Barnsley Town Centre Redevelopment

Application under S73 of the Town & Country Planning Act for minor material amendment to approved plans of the Library Building Reserved Matters Approval (ref: 2016/0924)

Covering Statement

CLIENT:	Barnsley MBC
PROJECT NAME:	Barnsley Town Centre: Phase 1 Library
IBI REFERENCE:	6742
VERSION:	1.0
ORIGINATOR:	KD
REVIEWER:	PS

BBTC_IBI_LR_A_F100_SE_001

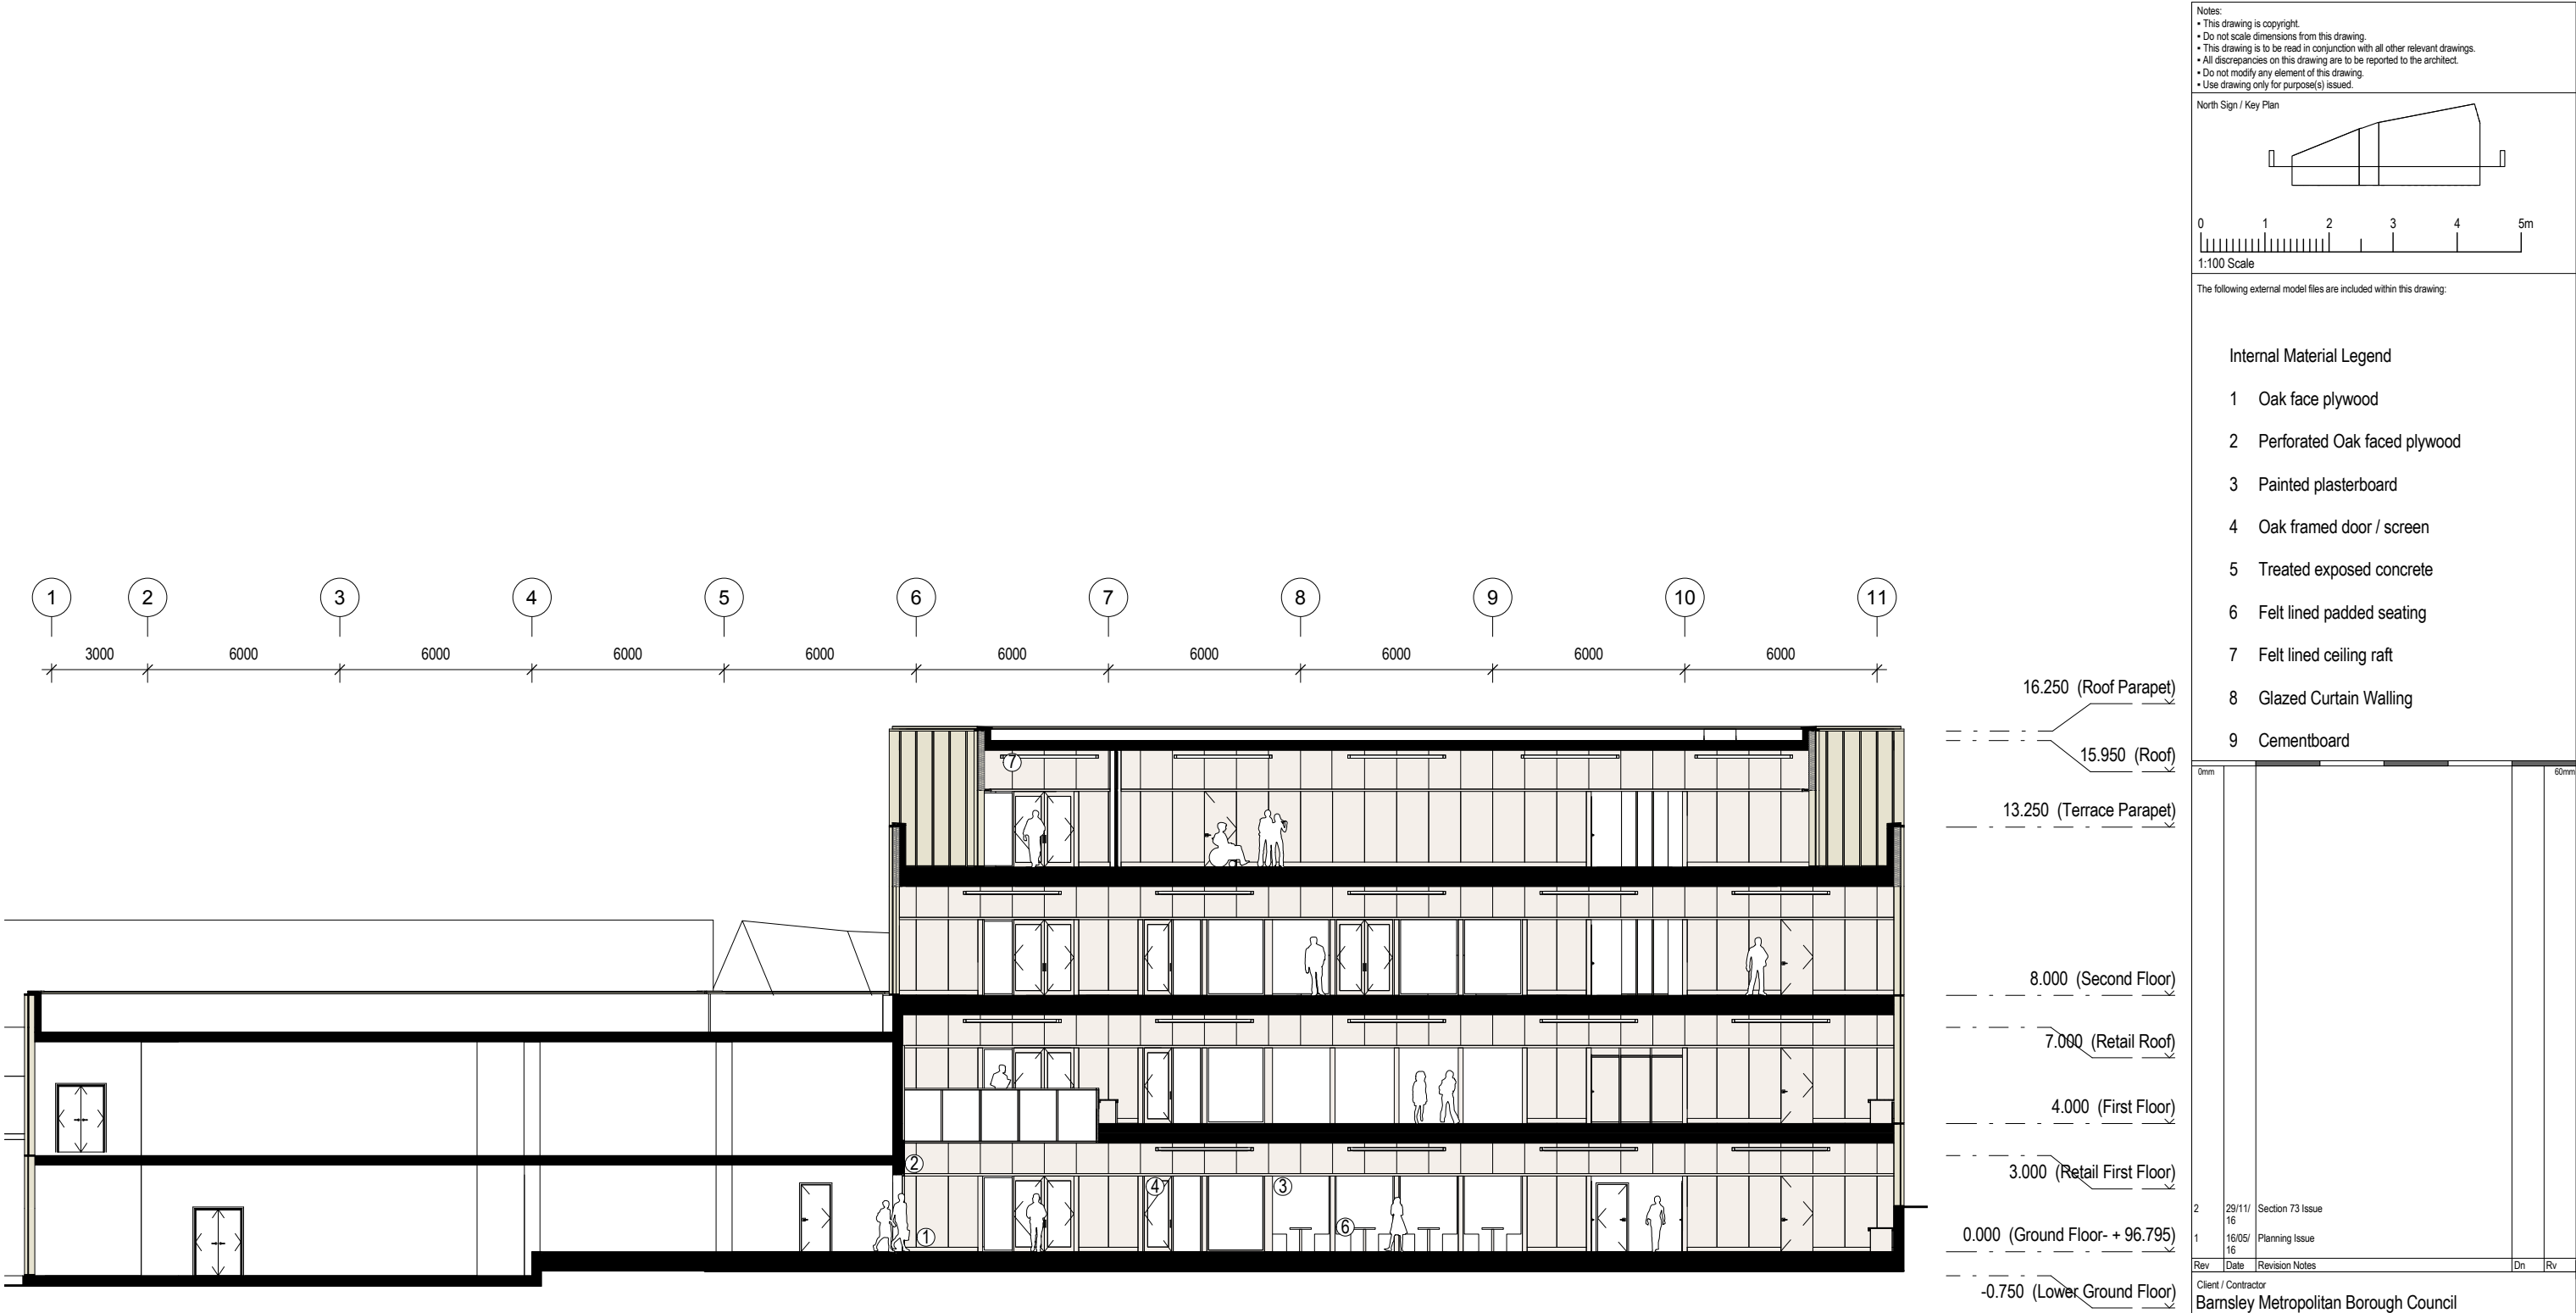
BBTC_IBI_LR_A_F100_PL_03 1 3F Plan	No change	Not required
BBTC_IBI_LR_A_F100_PL_RF 1 RF Plan	No change	Not required
BBTC_IBI_LR_A_F100_SE_001 1 Section AA	Yes– Mezzanine amended to Full First Floor and Glazing added at First Floor	BBTC_IBI_LR_A_F100_SE_001 2. Section AA
BBTC_IBI_LR_A_F100_SE_002 1 Section BB	No change	Not required
BBTC_IBI_LR_A_F100_SE_004 1 Section EE	No change	Not required
BBTC_IBI_LR_A_F100_SP_00 1 Site Plan	No change	Not required
BBTC_IBI_LR_A_F100_SP_XX_00 - Location Plan	No change	Not required
BBTC_IBI_XX_A_F100_PL_00_02 1 BBTC Site Phasing Plan	No change	Not required

Job Number	Drawing Originated Date	PAS 1192 Status Code
6742		
Scale@A3	Purpose	
As indicated	PLANNING	
Drawing Number	Revision	
BBTC_IBI_LR_A_F100_EL_001	3

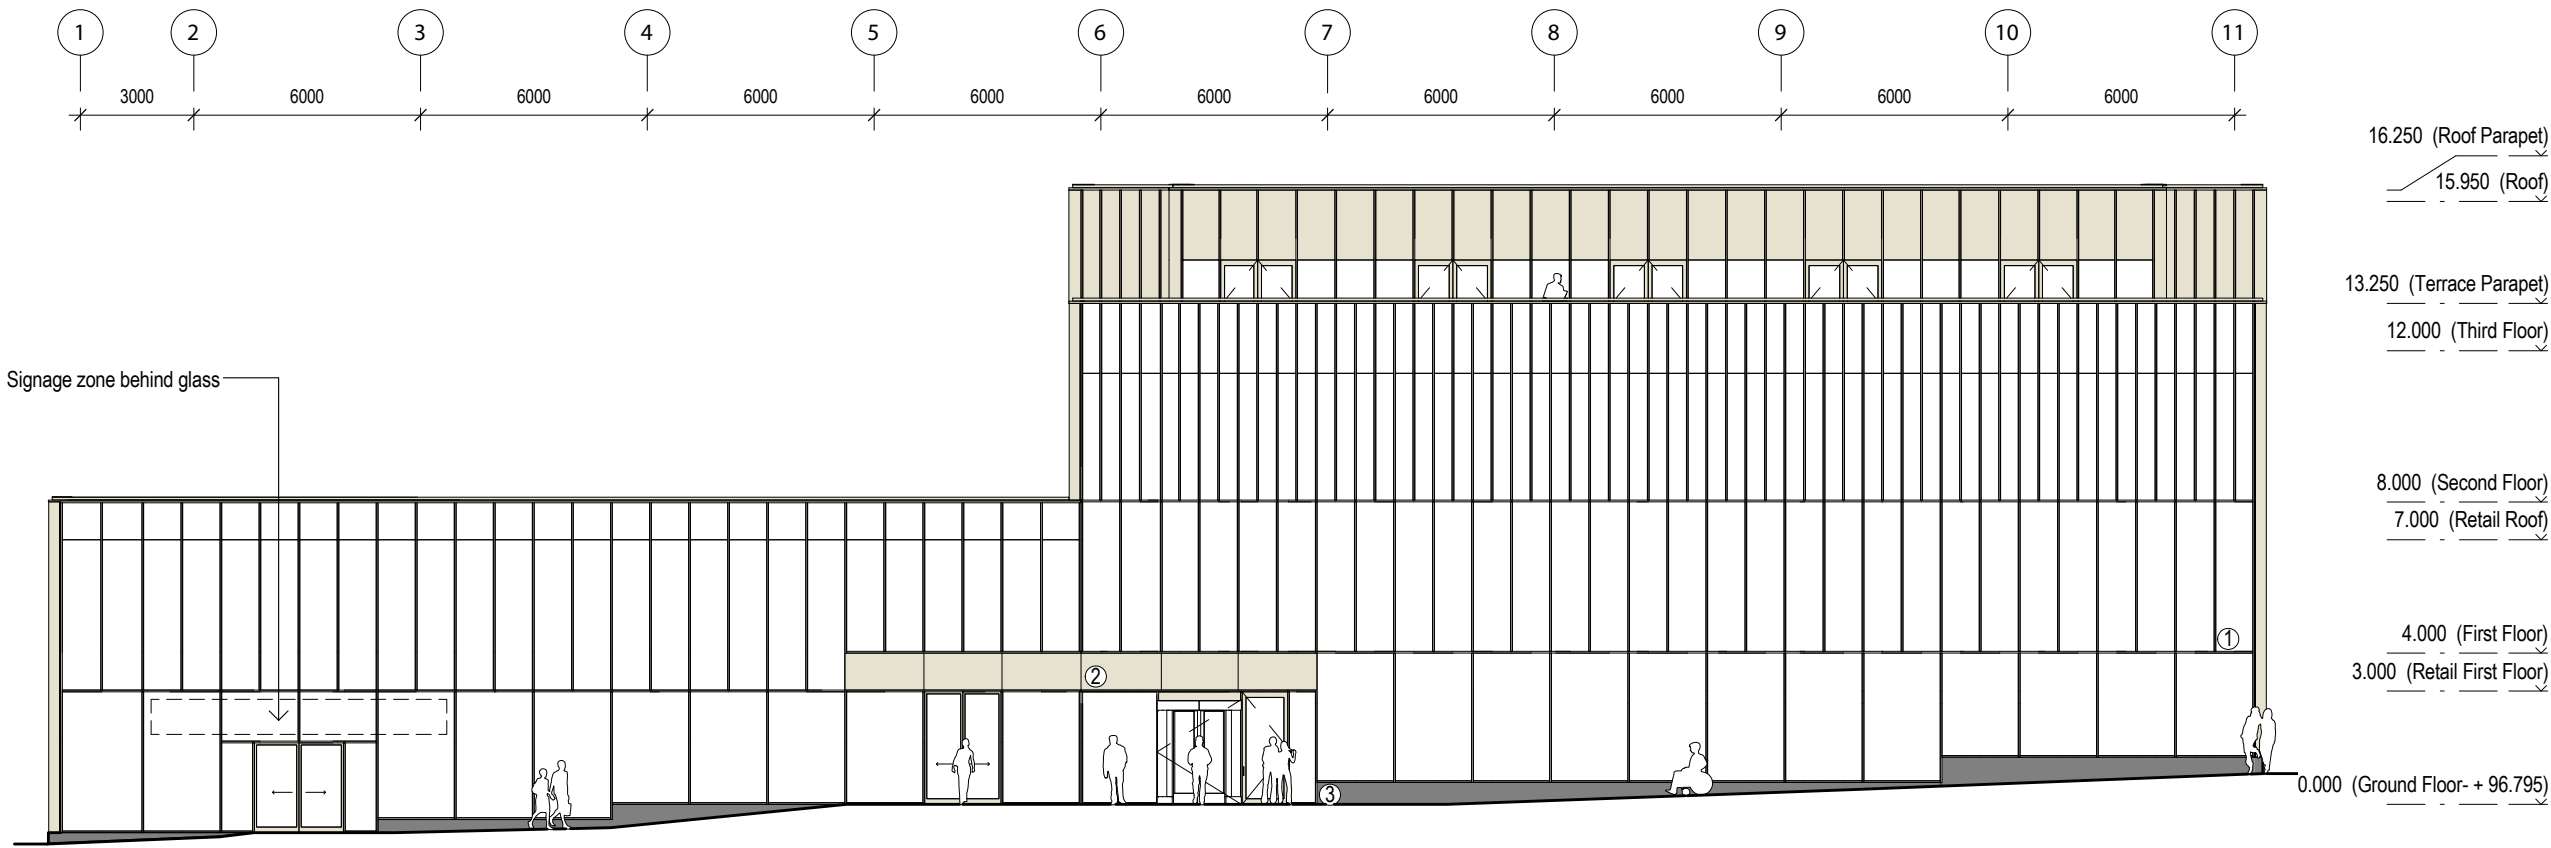
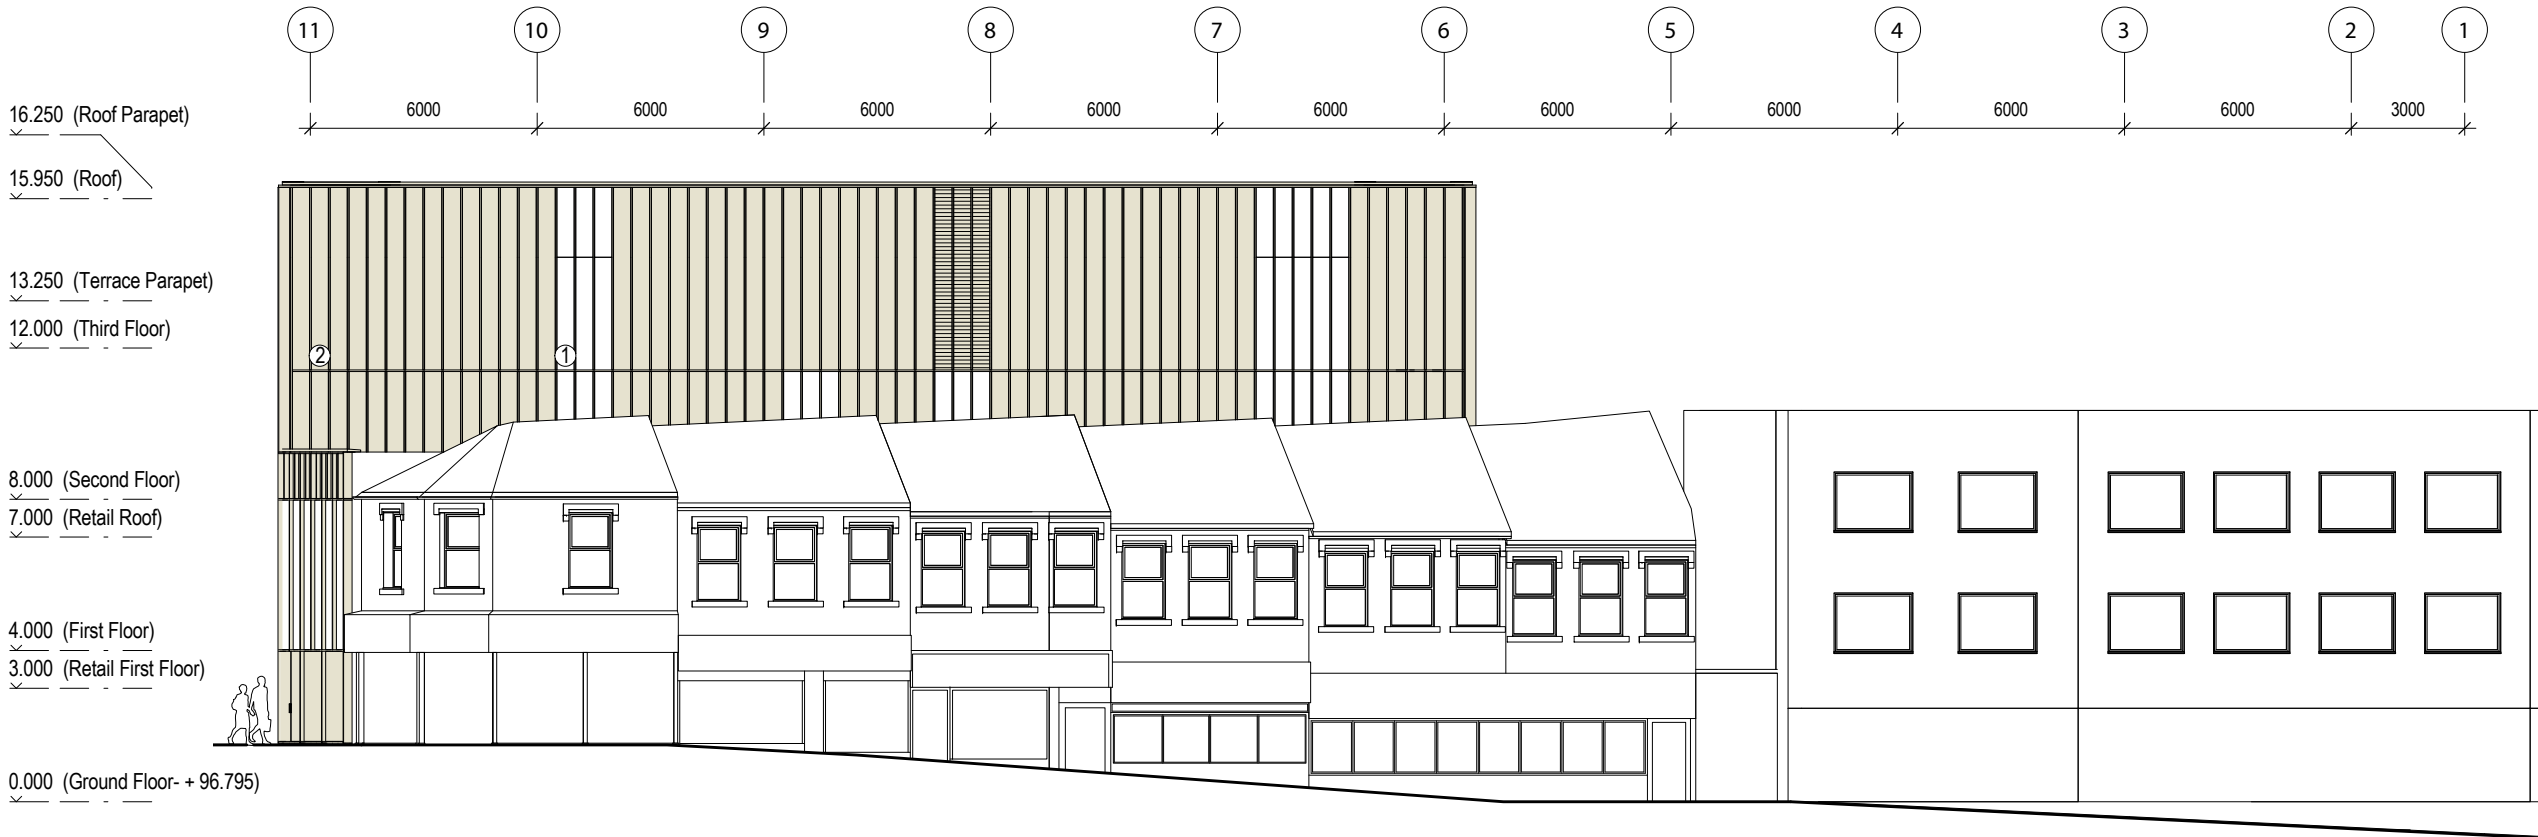
- Increase in floorspace of the café/restaurant area of 172m²
- Change to the first floor elevations on both the south and east of the building, from anodized aluminium to glazing.

Previously approved plan/ document	Proposed change:	Replacement Plan
PLANS		
BBTC_IBI_LR_A_F100_EL_001 2. Front and Rear Elevation	Yes – Glazing added at First Floor	BBTC_IBI_LR_A_F100_EL_001 3 Front and Rear Elevation
BBTC_IBI_LR_A_F100_EL_002 2. Side Elevations	Yes – Glazing added at First Floor	BBTC_IBI_LR_A_F100_EL_002 3 Side Elevation
BBTC_IBI_LR_A_F100_EX_EL_00 P1 Existing Elevations	No change	Not required
BBTC_IBI_LR_A_F100_EX_PL_00 P1 Existing Ground Floor Plan	No change	Not required
BBTC_IBI_LR_A_F100_EX_PL_01 P1 Existing First Floor Plan	No change	Not required
BBTC_IBI_LR_A_F100_EX_SE_00 P1 Existing Sections	No change	Not required
BBTC_IBI_LR_A_F100_EX_SP_00 1 Existing Site Plan	No change	Not required
BBTC_IBI_LR_A_F100_PL_00 1 GF Plan	No change	Not required
BBTC_IBI_LR_A_F100_PL_01 1 FF Plan	Yes – Mezzanine amended to Full First Floor	BBTC_IBI_LR_A_F100_PL_01 2 FF Plan
BBTC_IBI_LR_A_F100_PL_02 1 2F Plan	No change	Not required
